**PLANNING WORKSHEET 11 – DELEGATED / PCG REPORT - GENERAL**

<b>Application Ref.</b>	22/00863/FUL	
<b>Site Address</b>	Land Including Littlewood House Wheatley Road Sturton Le Steeple Retford Nottinghamshire	
<b>Proposal</b>	Demolition of an Existing Bungalow and erection of a Detached House and Garages with new vehicular access	
<b>Case Officer</b>	Eleanor Grant	
<b>Decision Level</b>	Delegated	
<b>Recommendation</b>	Refuse	
<b>Reason(s) for PCG referral</b>		
<b>PCG Sign off and date</b>		
	<b>Signature</b>	<b>Date</b>
<b>Case Officer</b>	Ellie Grant	09/08/2022
<b>Authorised signing Manager</b>		10 <sup>th</sup> August 2022

client	Mr and Mrs B. Foster	drawing	Proposed Garage Plan and Elevations	date drawn	10.05.2022
project	Little Wood House Sturton le Steeple DN22 9HU	scale	1 / 50 and 1/200 @A1	drawn by	JB
status	PRELIMINARY	rev	C

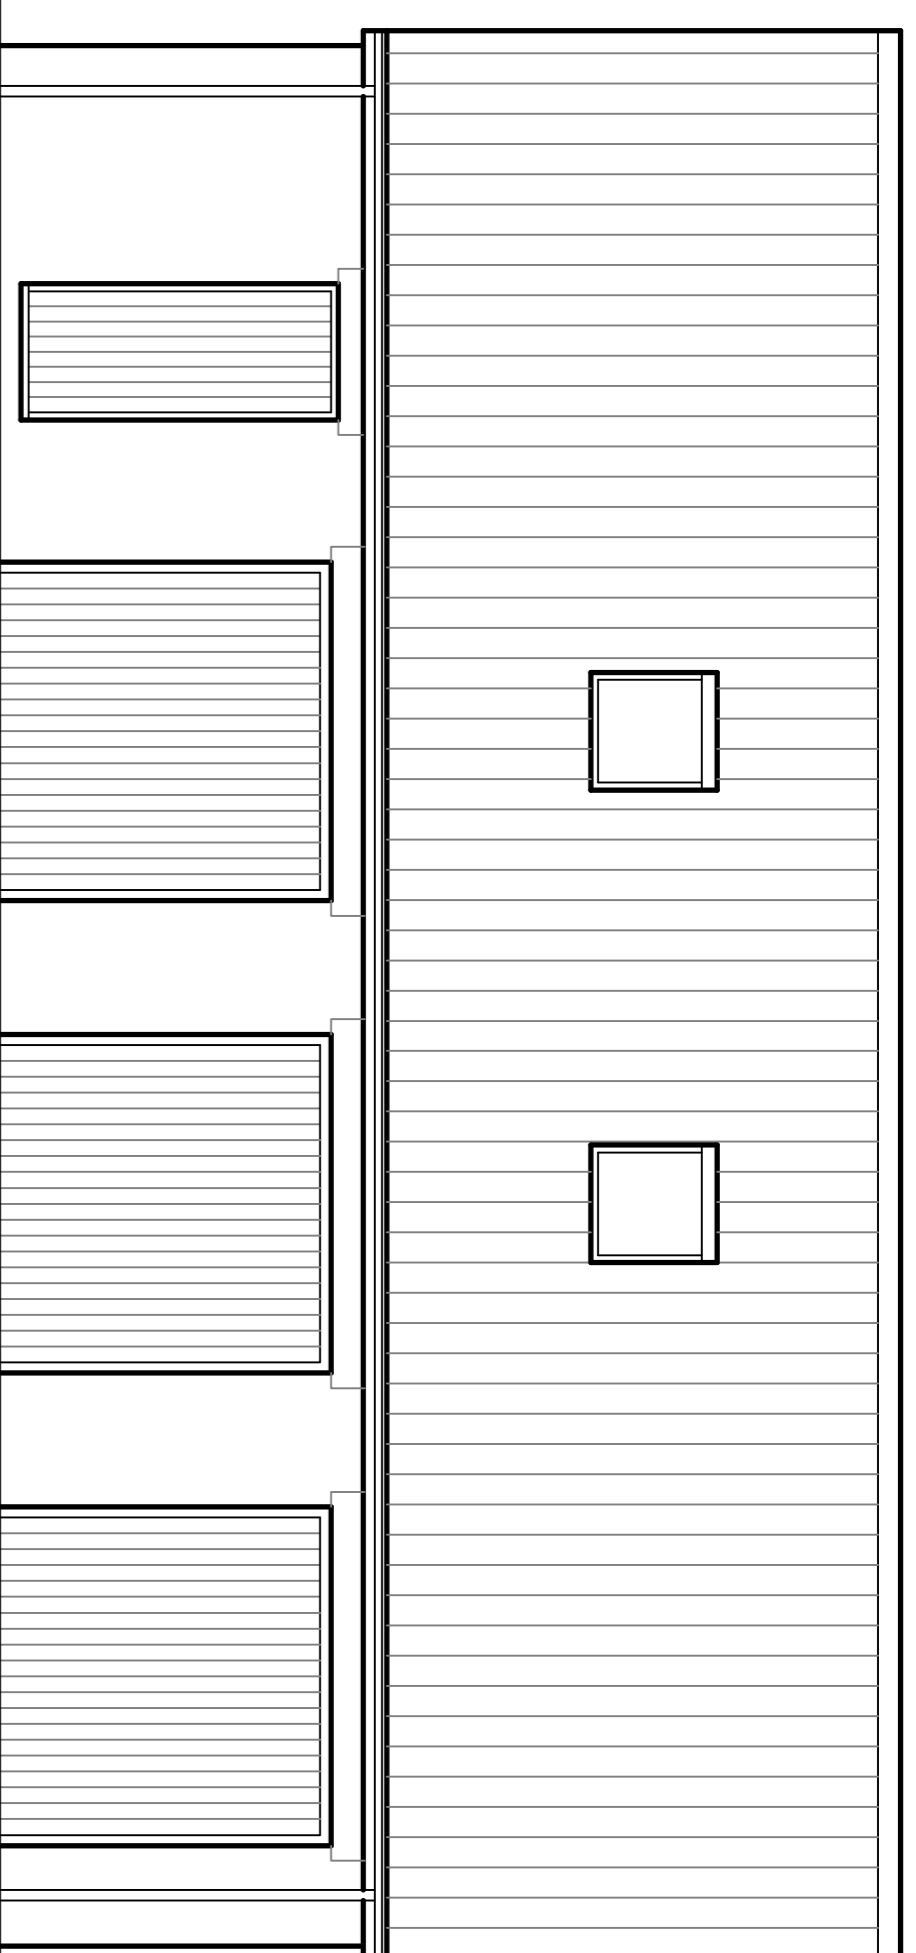
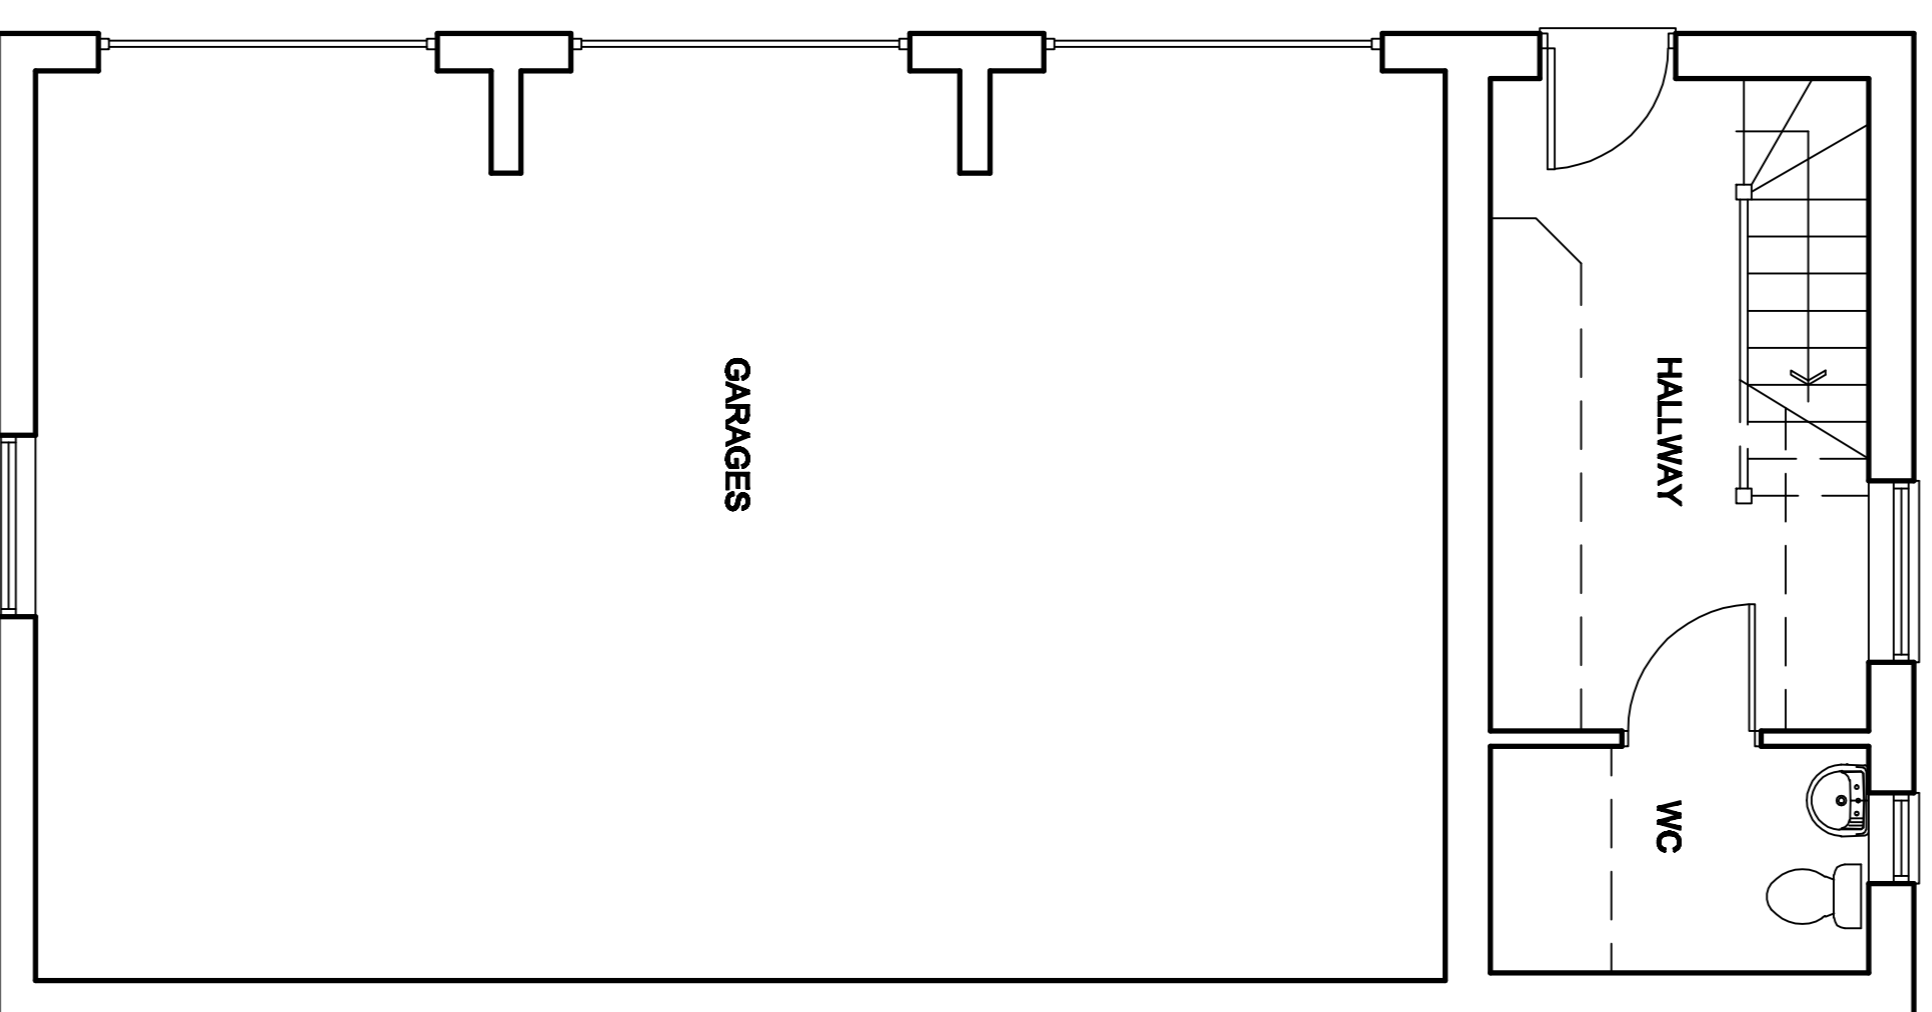
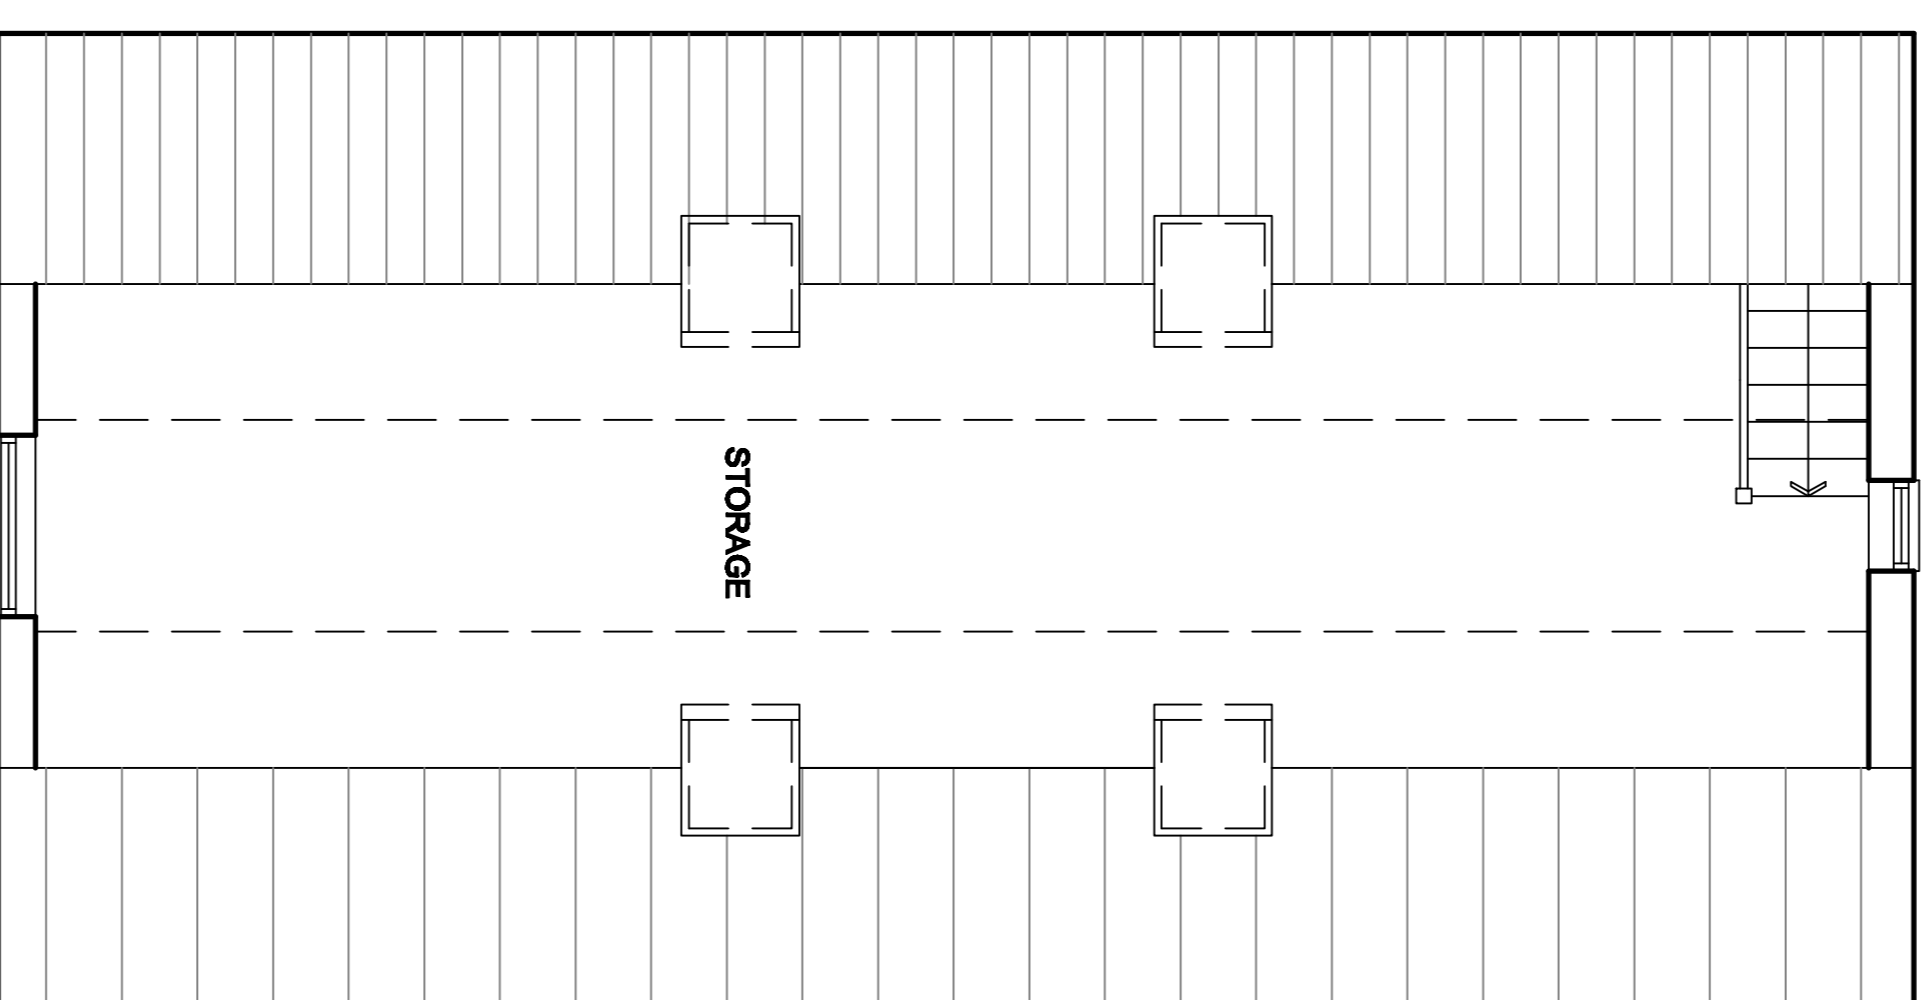
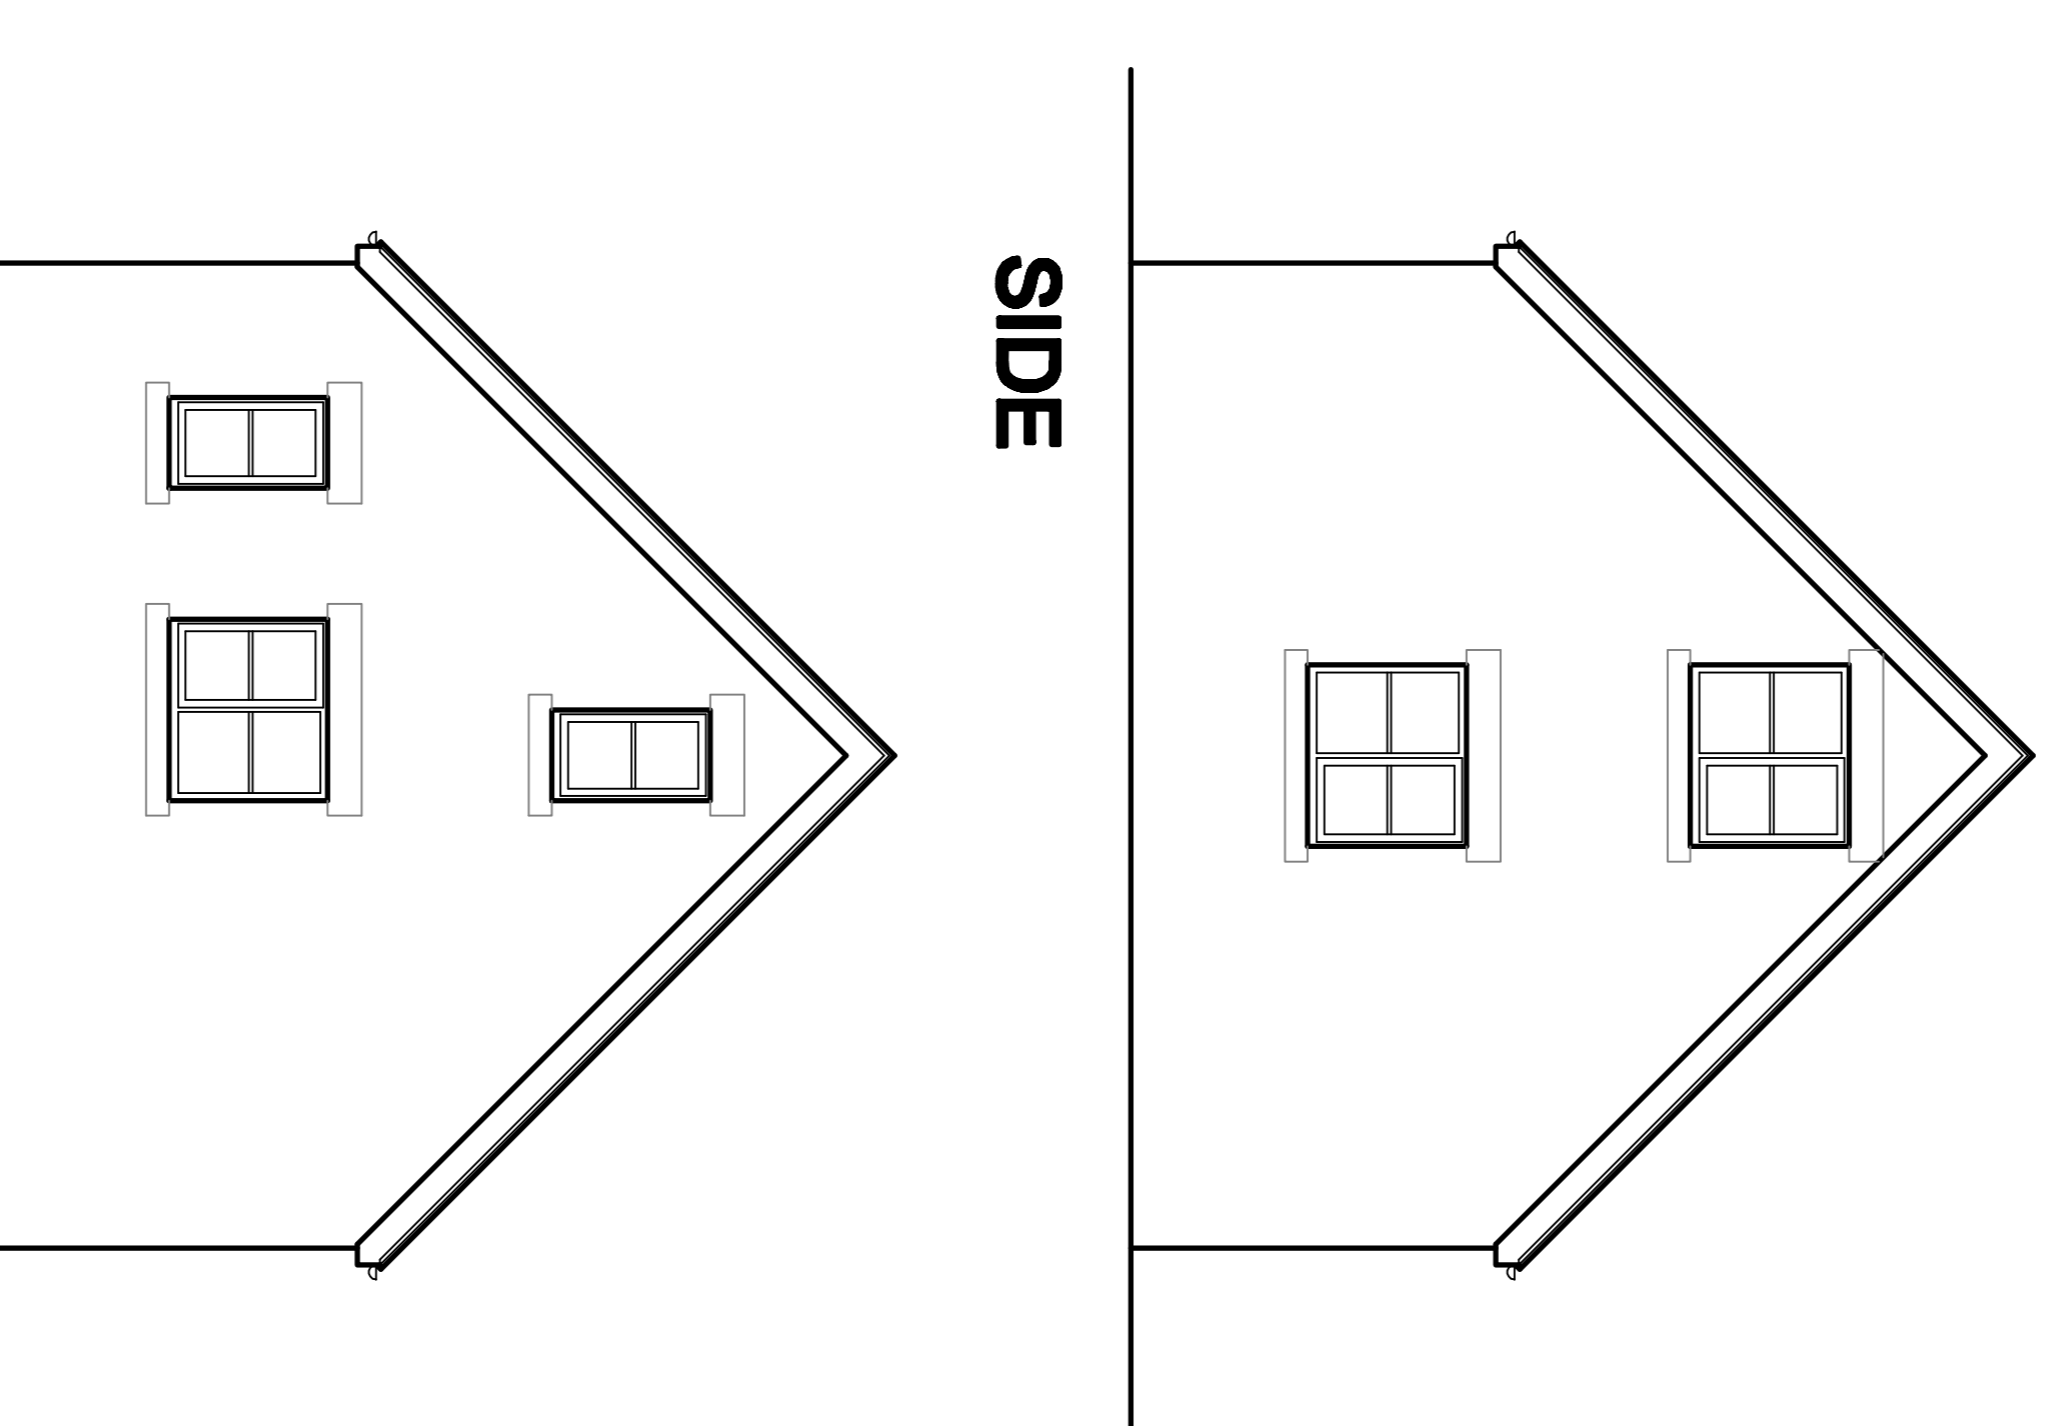
The garage is also considered to be of an overly-large scale within the immediate surroundings. The principle of a garage to the front of the house is acceptable and can be seen at High Pasture to the north-west. However, there are concerns in regards to the scale of the proposed. The garage will be comparable in size to the dwelling adjacent granted under 17/01673/FUL (since lapsed). The garage will also have a first floor for storage which may have the potential to be used as ancillary accommodation or a separate dwelling.
